COMMUNITY MEETING REPORT

Petitioner: The Paces Foundation

Project: Kendell MF, 2023-124

Purpose: To present the Conditional Rezoning Petition 2023-124 to any neighboring residents or homeowners who were in the rezoning mailer radius or who spoke to the Petitioner or Petitioner’s representatives and were invited. Urban Design Partners recorded the presentation to be publicly posted on our website for community benefit.

Rezoning Plan
 Charlotte, NC 28214

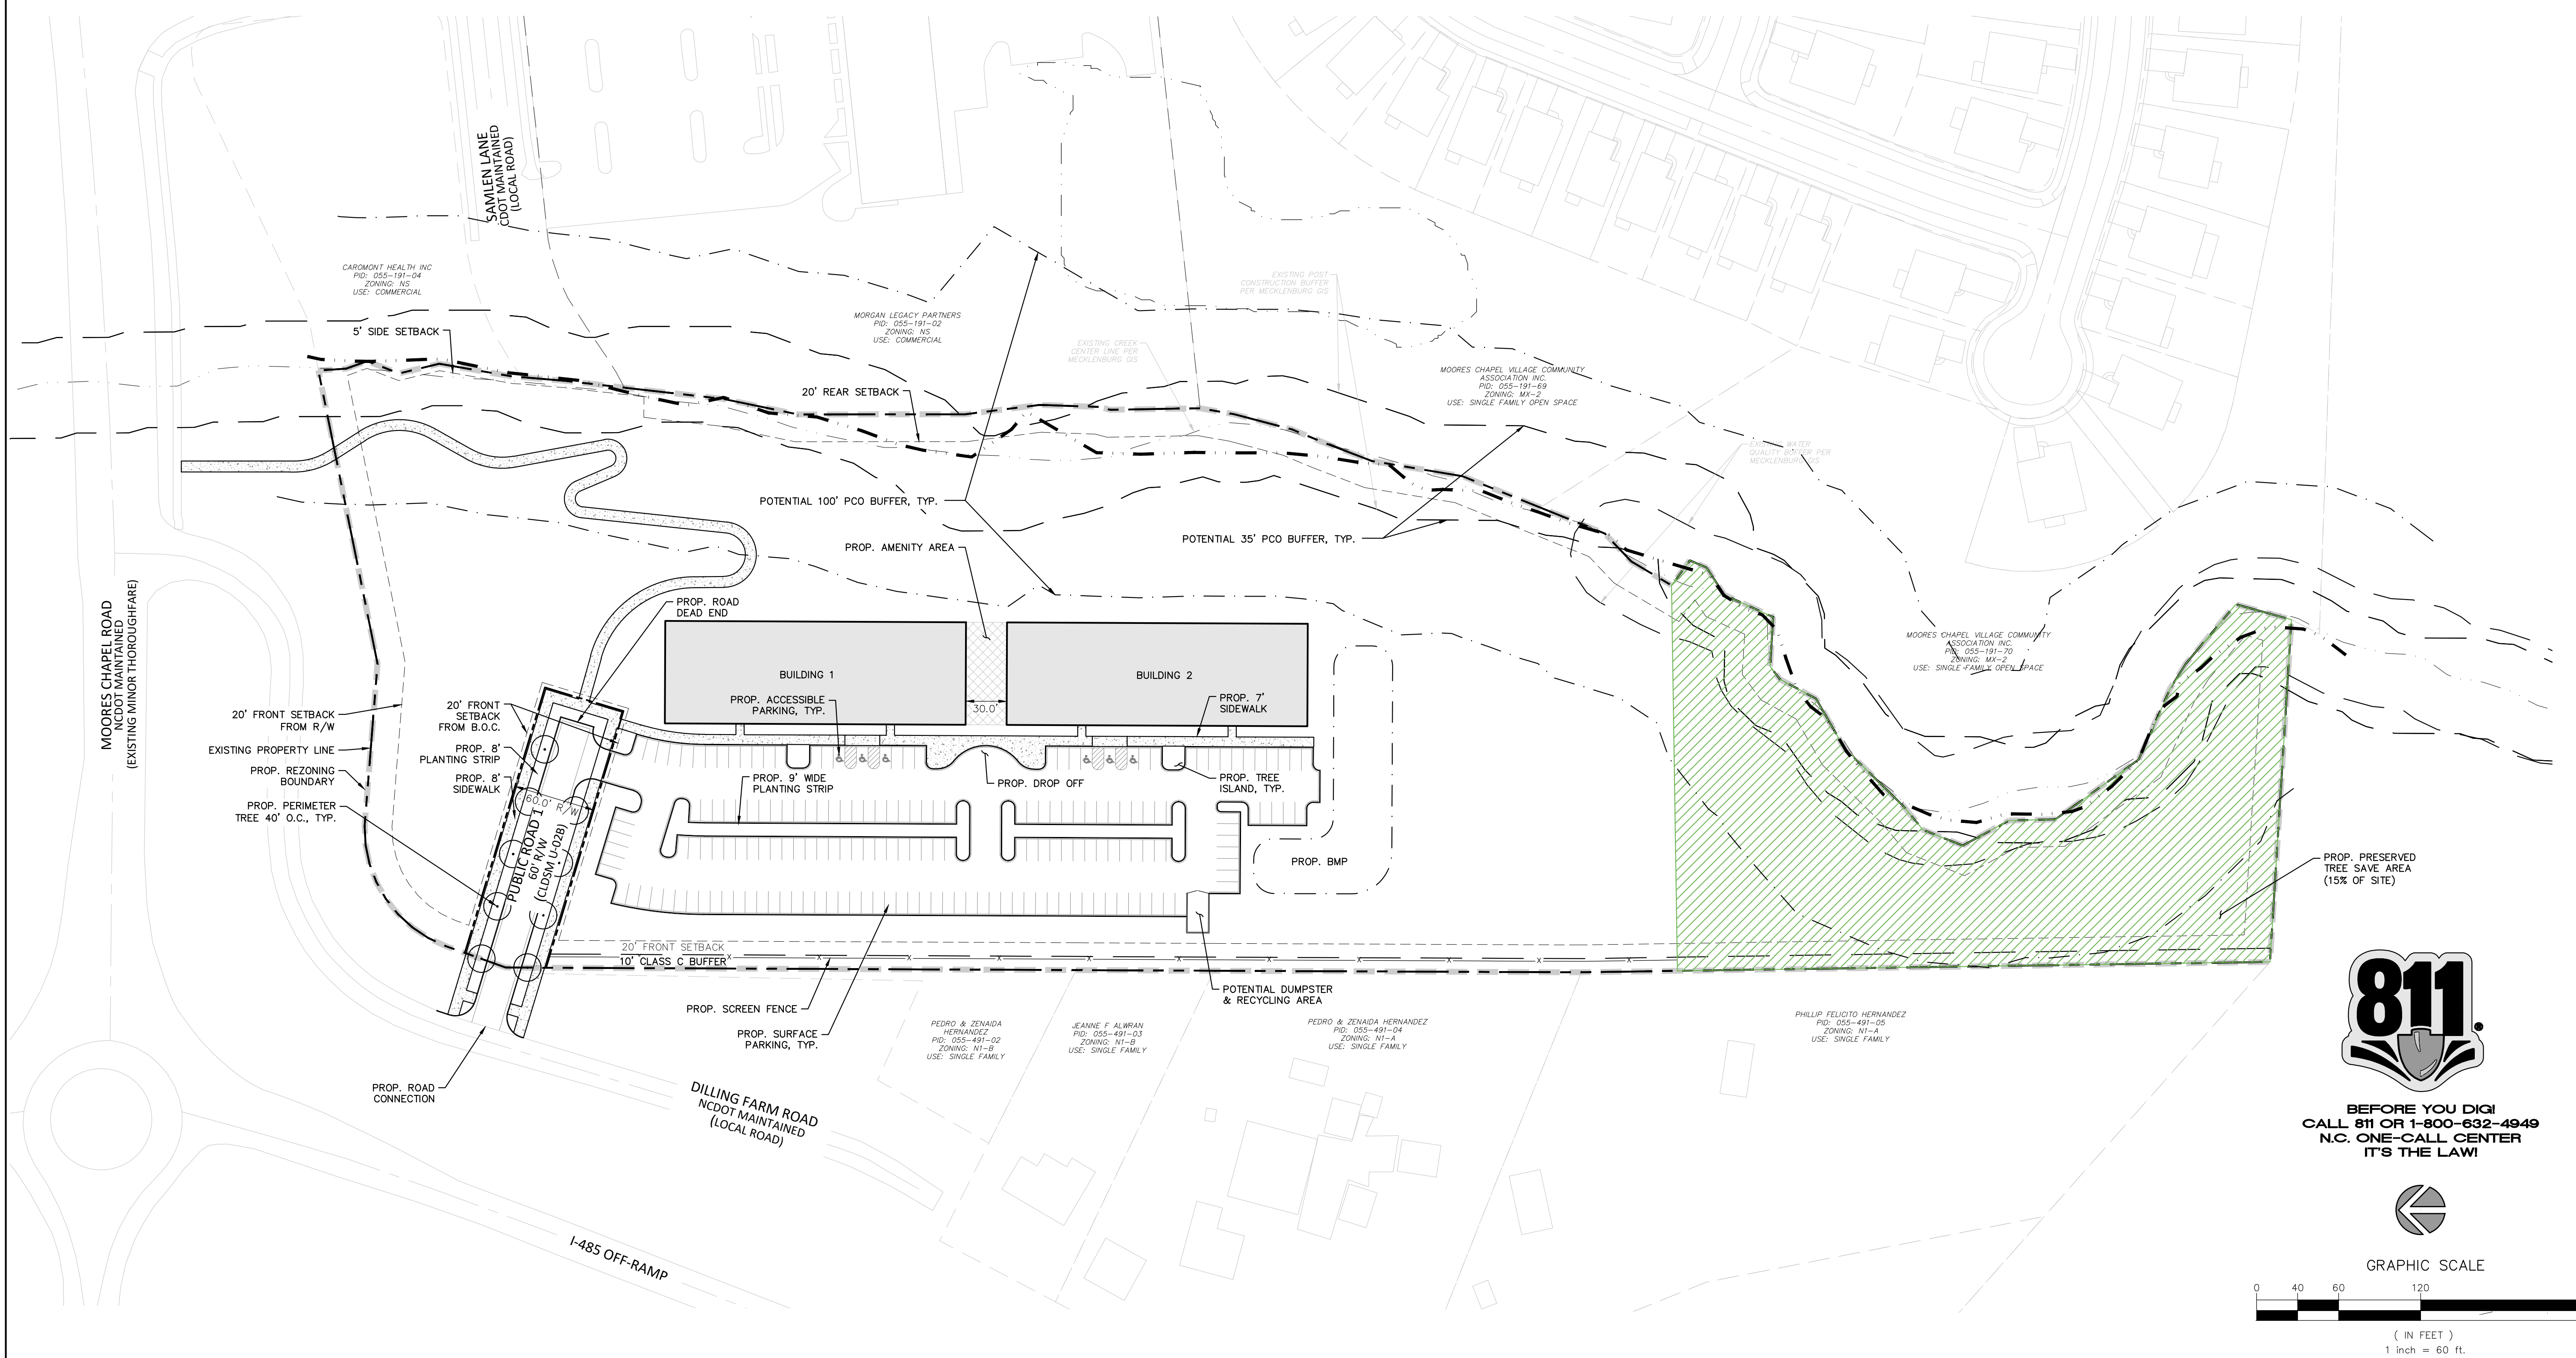
1. Is there a buffer between the proposed buildings, houses, and shopping center?

3. Is there a way residents can get from the complex to the shopping center without accessing Moores Chapel Road?

4. Is there a way to connect to Samlen Lane?

7. Is there a way to make this an L-shape building instead of two buildings.

9. Is it possible to add a common amenity area to the site?

A: Yes, a landscape buffer will be provided around the property. The shopping center and residential neighborhood have over a 100' buffer.

A: We're providing a pedestrian connection from the site to the existing sidewalk along Moores Chapel Road. Residents will be able to access the shopping center without driving.

A: There's a significant topographical change from the existing drive across the creek. A road or walking path would require a bridge to be built.

A: We can explore additional design and building options.

A: Yes, the community will likely have gardening areas and other amenities.
